Department of Transportation

January 14, 2019

RE: Springs East at Waterview (EA-16-105_CS183_P-17-006_SF-16-017, SP-16-005, & SP 17-010); Preliminary Plan of Springs East Residential & Commercial Development - **REVISED**

CDOT Access and Operations has reviewed an updated/revised Traffic Impact Study (TIS), dated 08/24/2018 and comments are as follows:

Short-Term Bradley Road Lane Recommendations

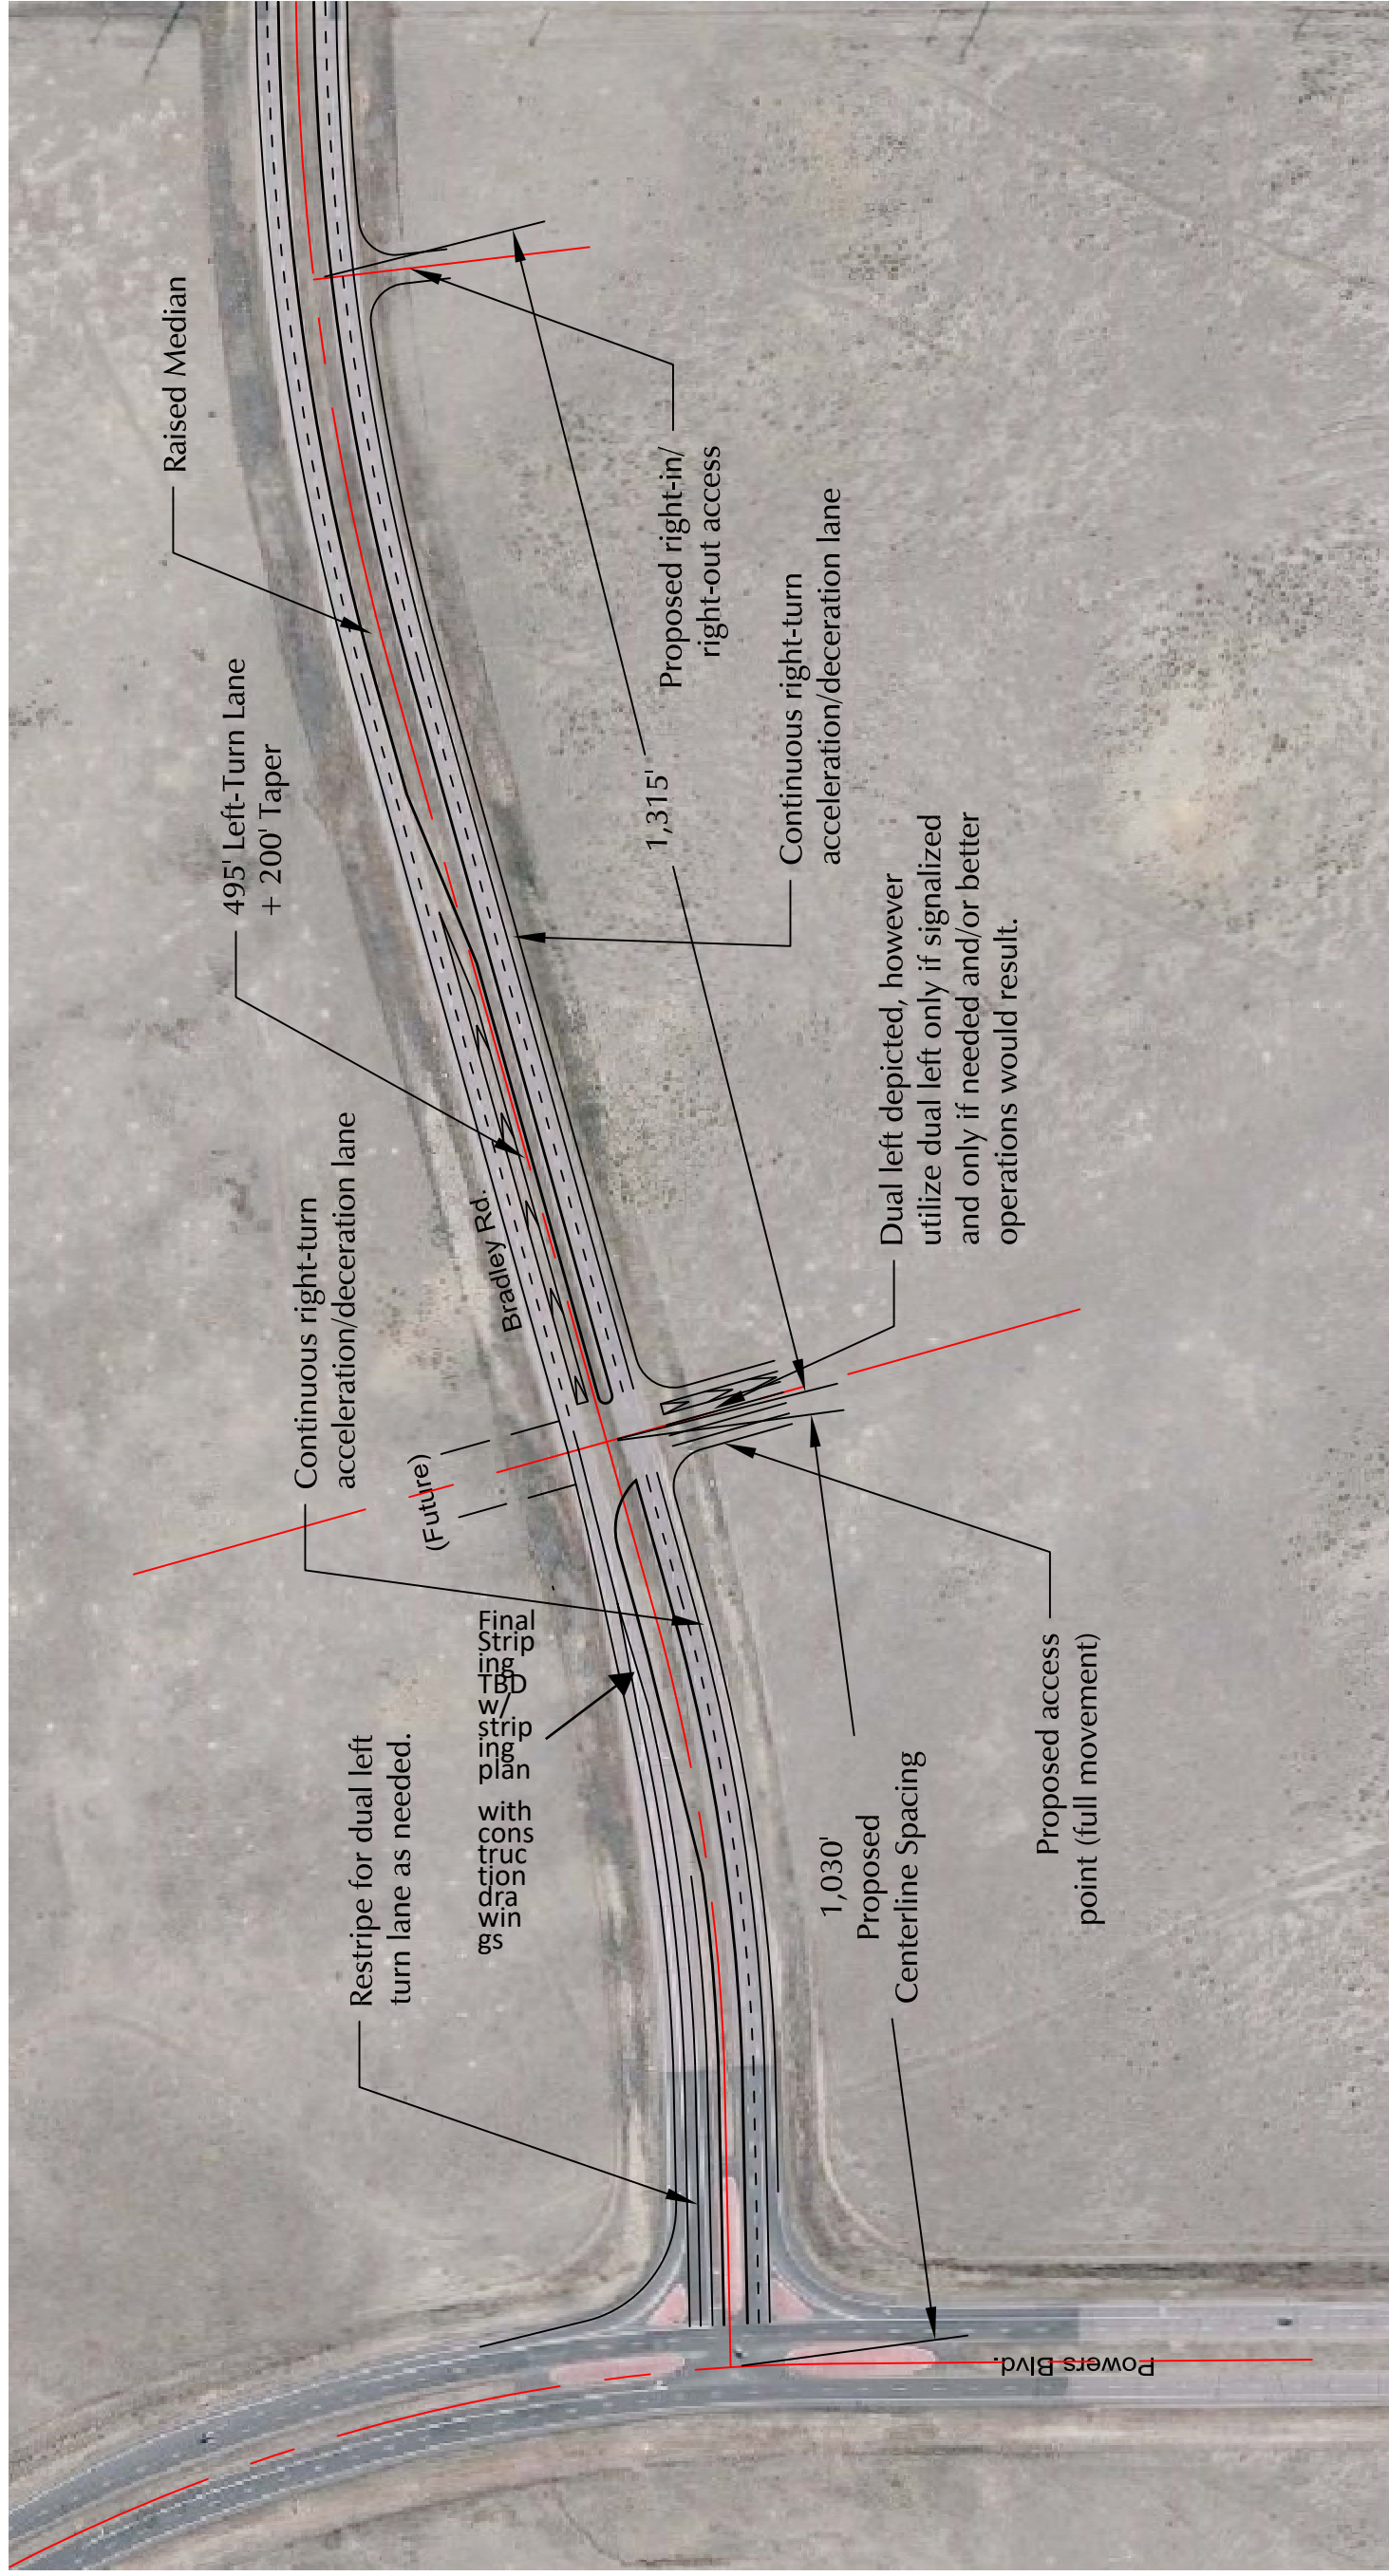
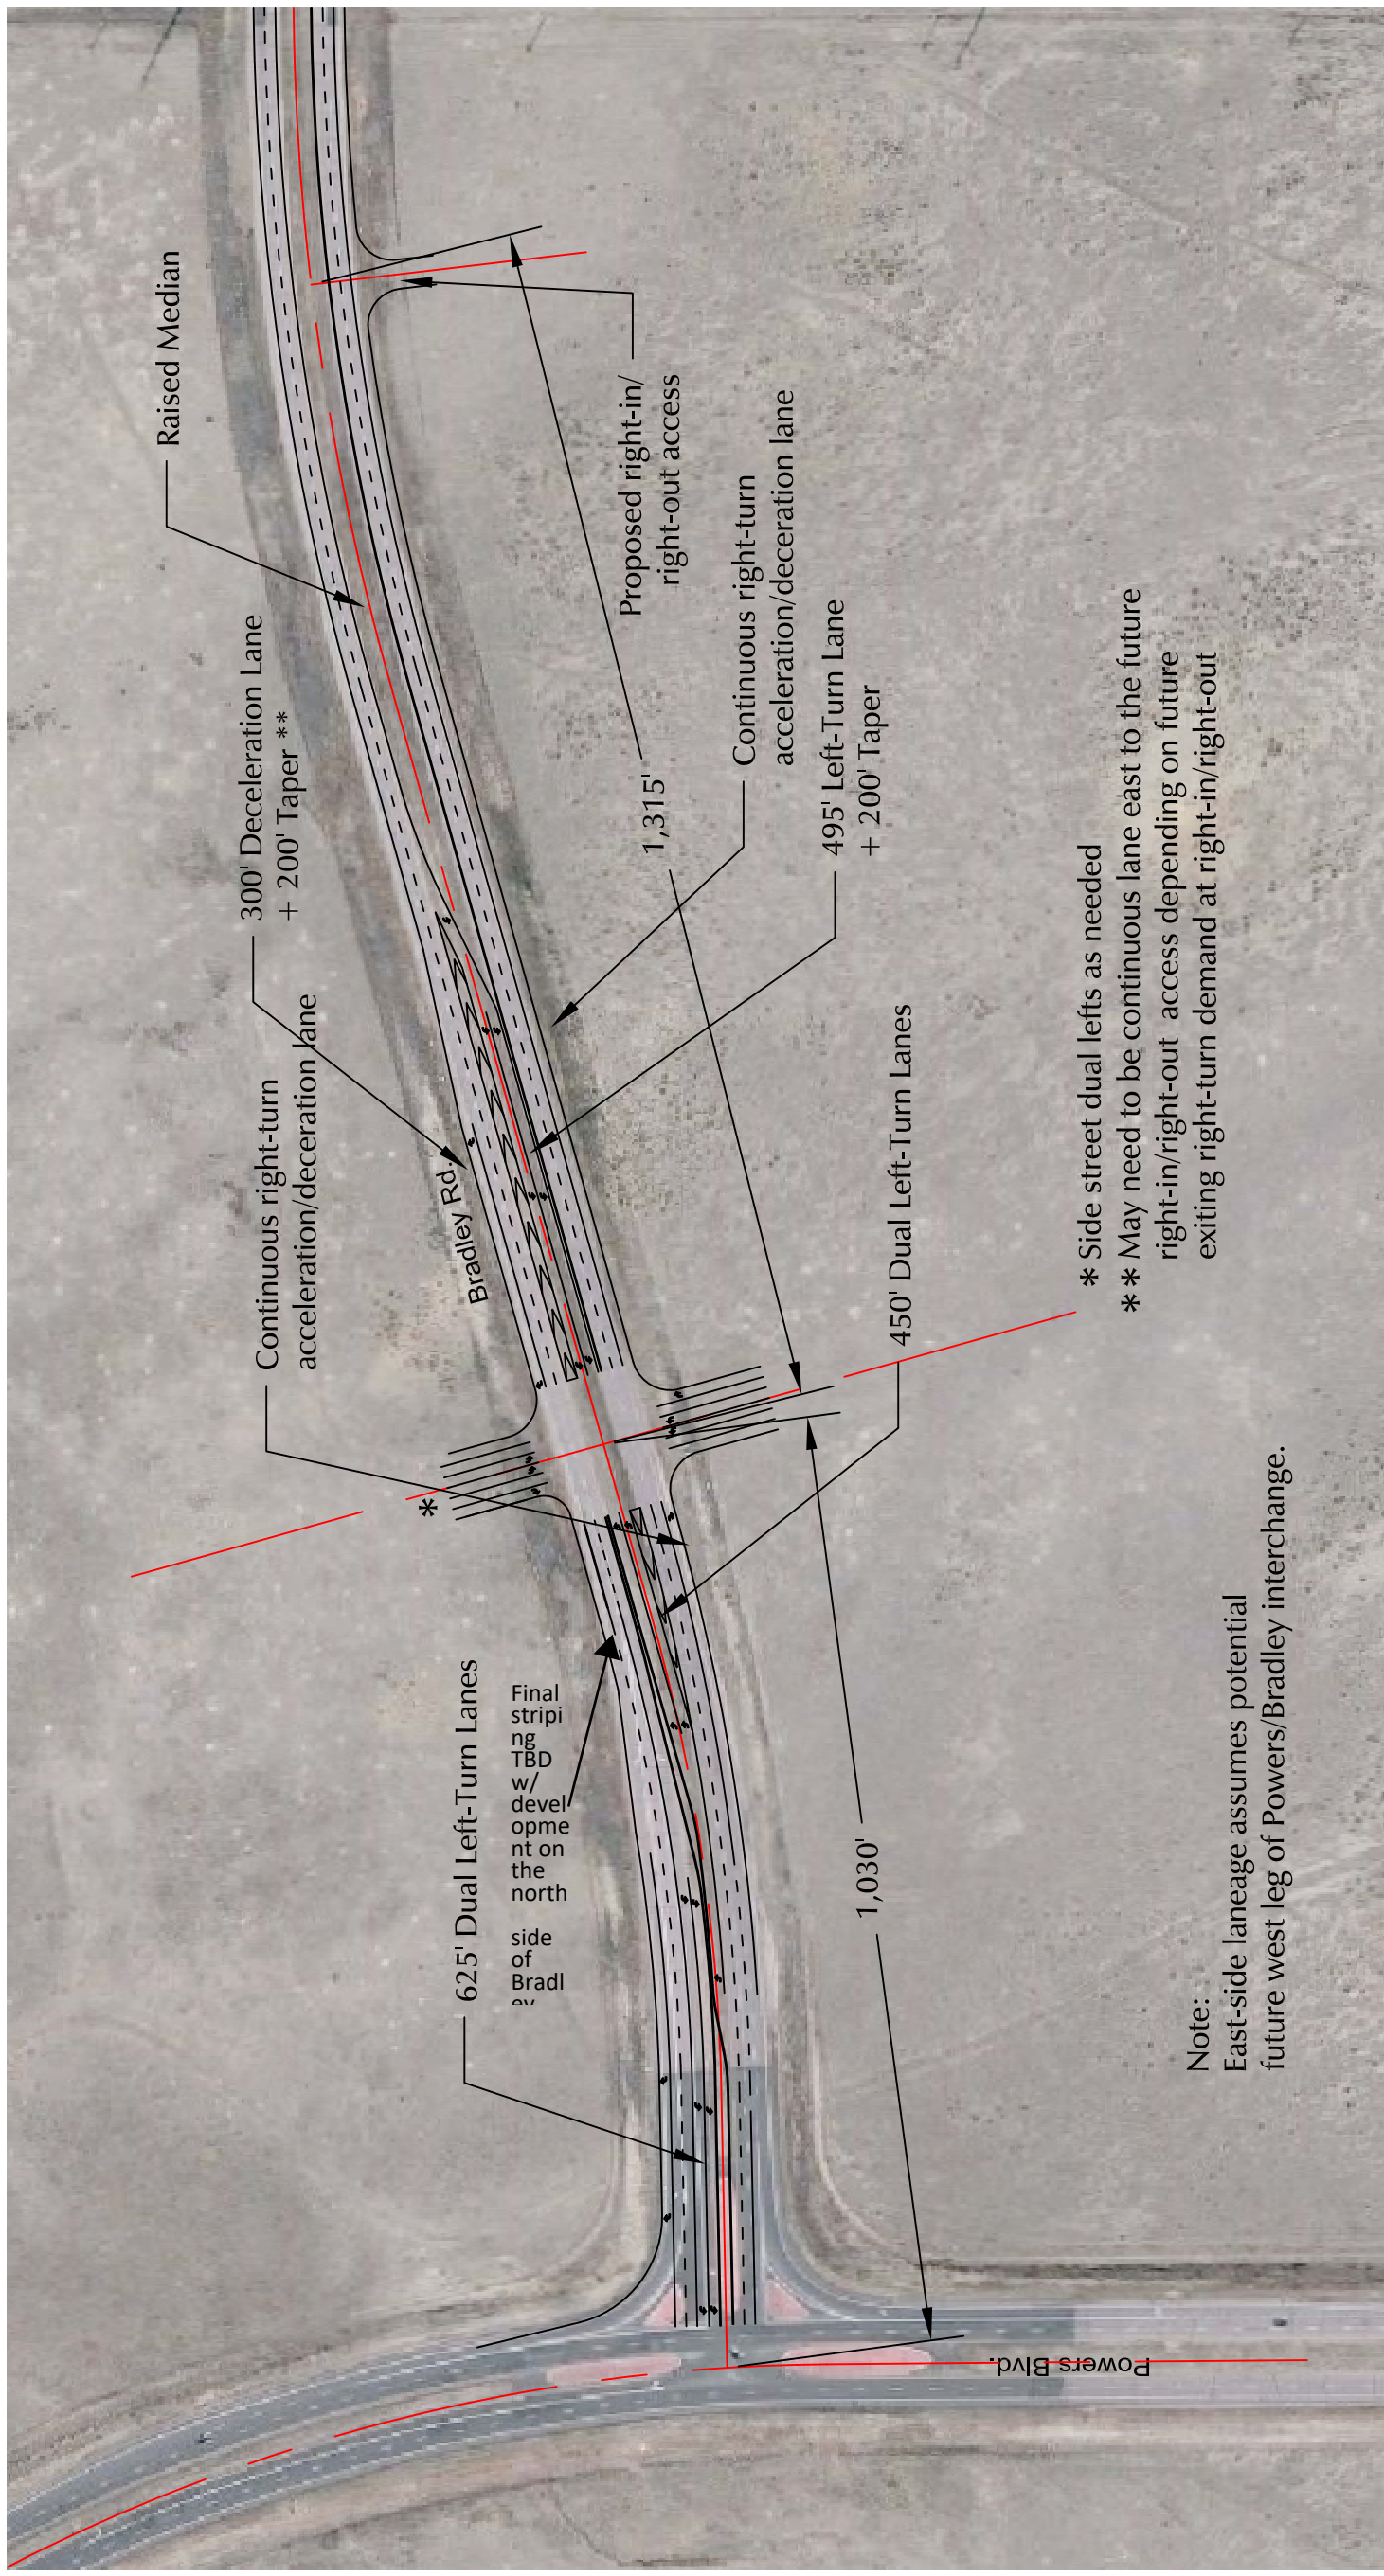
- Page 6 states that the southbound left turn lane on Powers Blvd can be restriped as dual left turn lanes, however there is no road surface for such restripe; a 150-ft long raised median exists at that location. This will need to be mitigated by the development, with approval of the Department through the Access Permitting Process.

- Bradley Road has been restriped for dual westbound left turn lanes when the signal was installed. Incorrect in the TIS.
- The 2040 assumption of a six-lane Powers Blvd at Bradley overlooks the cost comparison of an interchange versus widening three miles of highway particularly with ADTs only at 40,000. The study should include an interchange alternative of 2040 traffic. Update info needed.
- Figure 19 depicts the long-term Bradley Road lane configuration east of Powers Blvd. It is clear from the drawing that the future eastbound left turn lanes for the future north side access will conflict with the future northbound ramp intersection. Mitigation required.
- Therefore, a revised Traffic Impact Study is required.
